Dear Miss Greenwood,
Your ref: HA/2018/120208/01-L01
LA Planning ref: FG/206/17/PL

Re: INSTALLATION OF SIX PUMP (12 FILLING POSITION) PETROL FILLING STATION, DRIVE-TO PAY KIOSK & ASSOCIATED WORKS INCLUDING JET WASH, AIR/WATER SERVICES & VACUUM EQUIPMENT.

LAND AT ASDA SUPERSTORE LITTLEHAMPTON ROAD FERRING BN12 6PN

Cross Section Showing the Proposed USTs Location
 Vertical Scale: 1:85 Horizontal Scale: 1:263
 E13043/2: ASDA Worthing Ferring
 Prepared For: ASDA Stores Limited

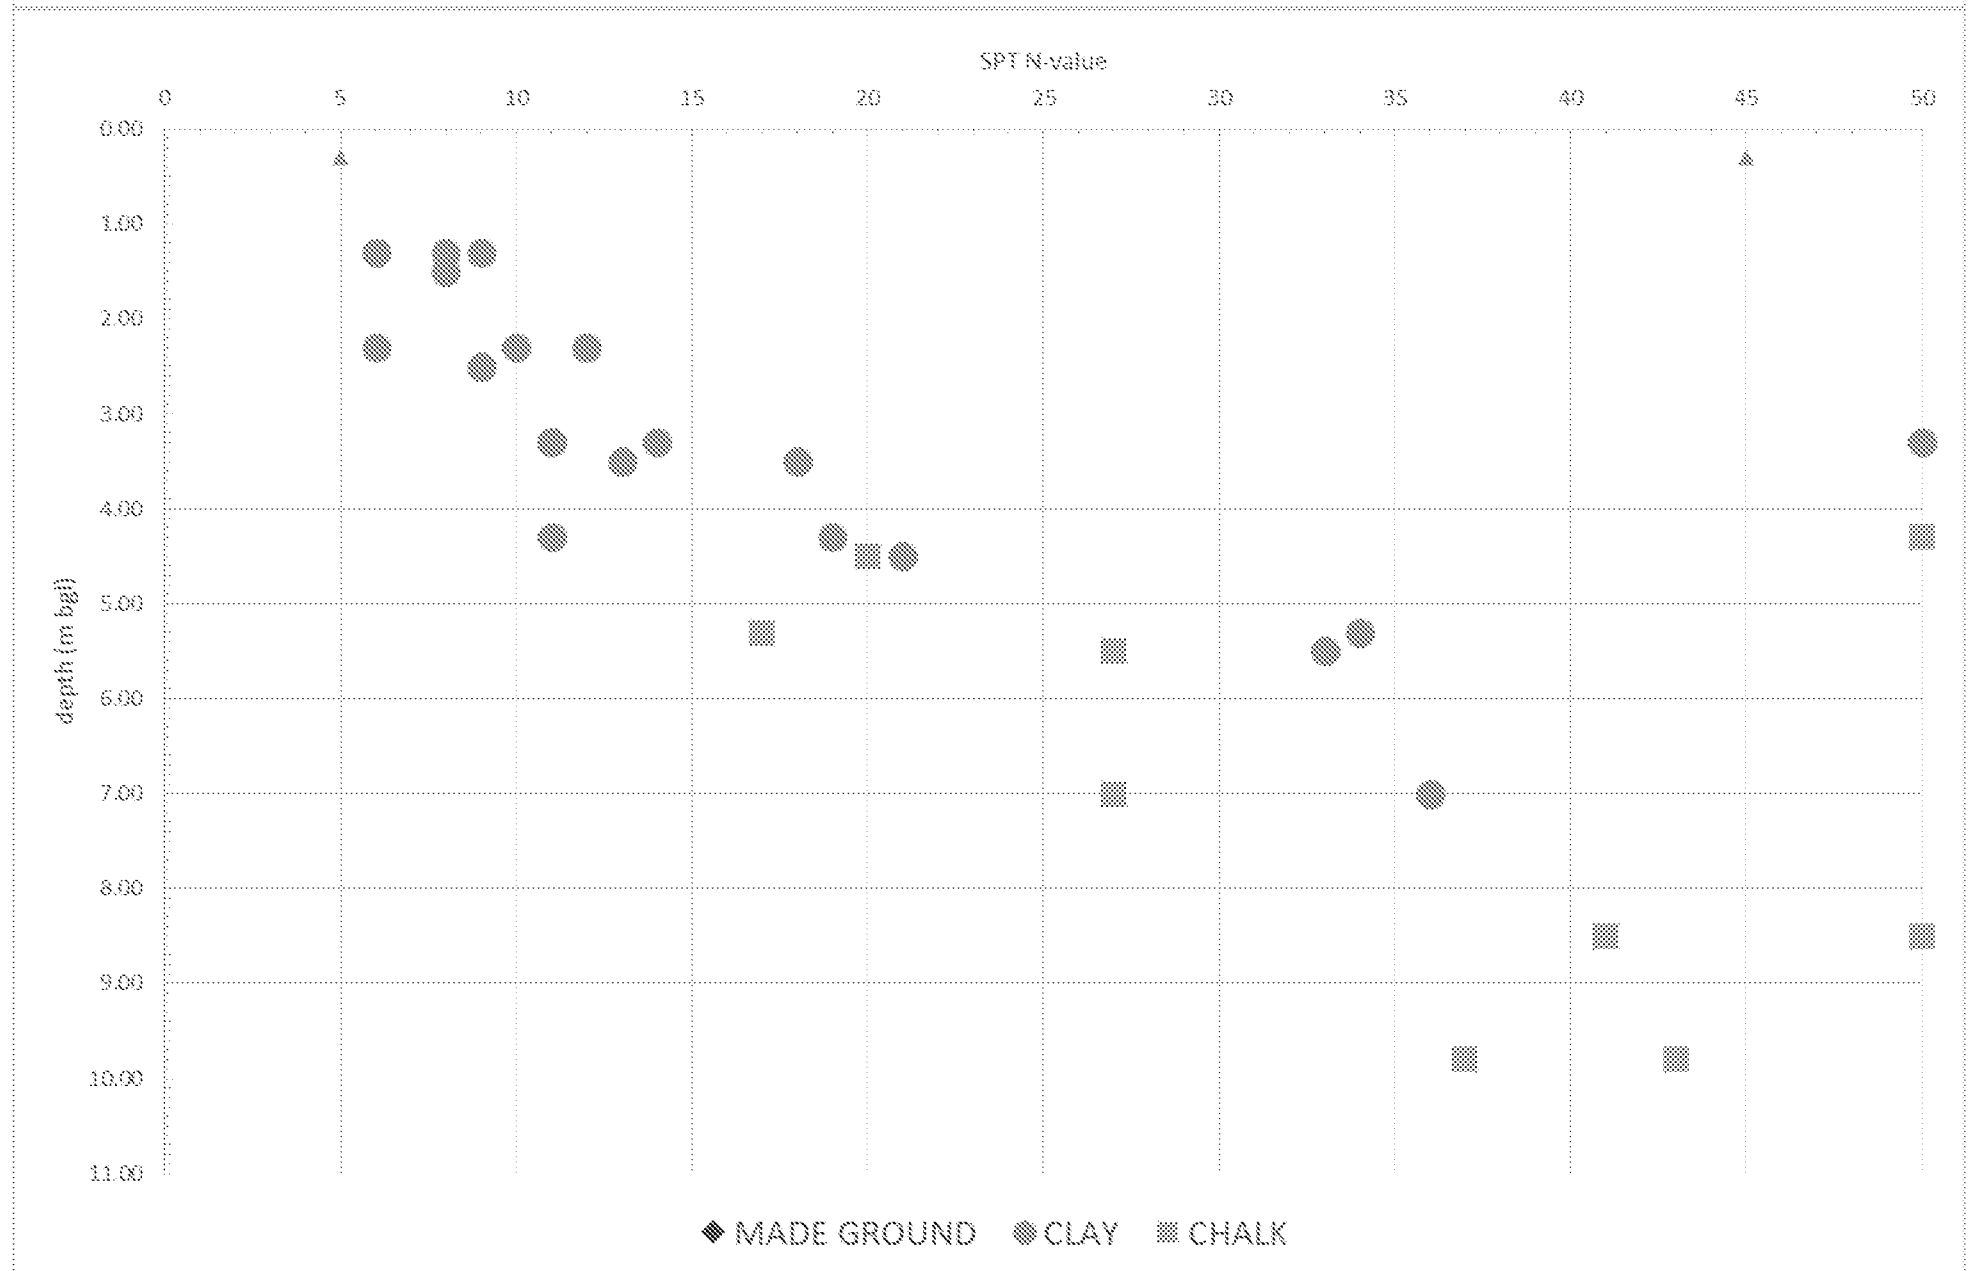
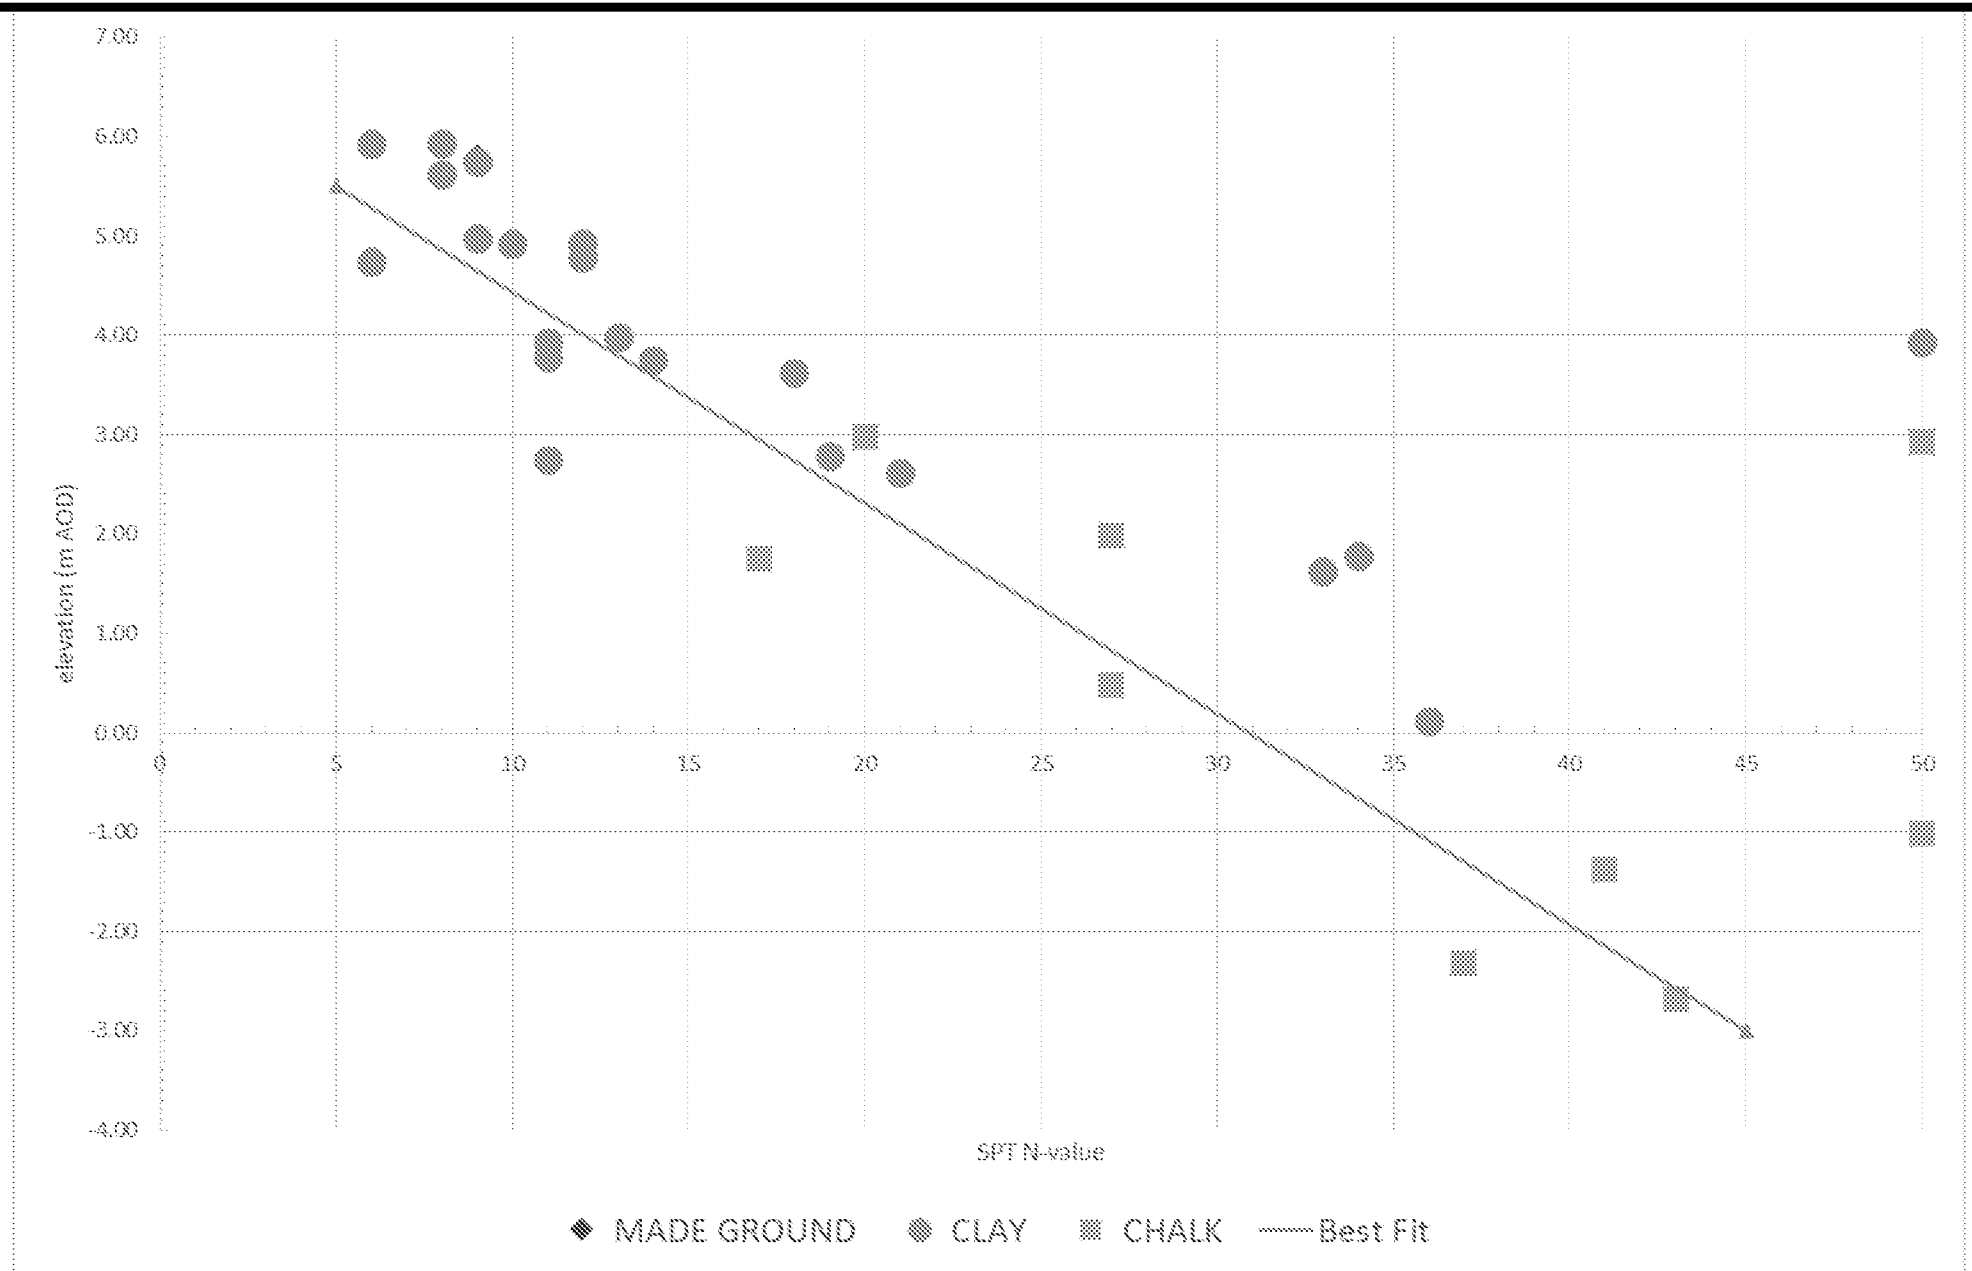
The proposed design of the underground tanks is inadequate. As the proposed tanks are to be developed below ground, groundwater levels may be such that they are sited below the groundwater table. We therefore recommend that the applicant addresses this environmental

risk, particularly with our Position Statement D2 and present a design that mitigates against any future pollution.

The Geo-Environmental investigation boreholes conclude that the chalk layer (Lews Nodular Chalk Formation) falls away sharply across the site to the North from max height of approx. 4.03 AOD (WS1) to -0.08 AOD (BH2) and has a consistent superficial clay barrier (Aeolian Deposits) between that and the upper layers. Consistent water strikes were encountered in BH1 & BH2 at average approx. depth of -1.00 AOD. Inconsistent water strikes were found within the upper layers which it is reasonable to conclude is perched water trapped within the superficial clay.

The tanks have been located in a linear format to the most Northerly part of the site (refer to '400_02 Geo-Environmental Appraisal Section') which ensures that the below ground tank installation does not a) breach the superficial clay barrier into the chalk layer below and b) is not situated below the groundwater level.
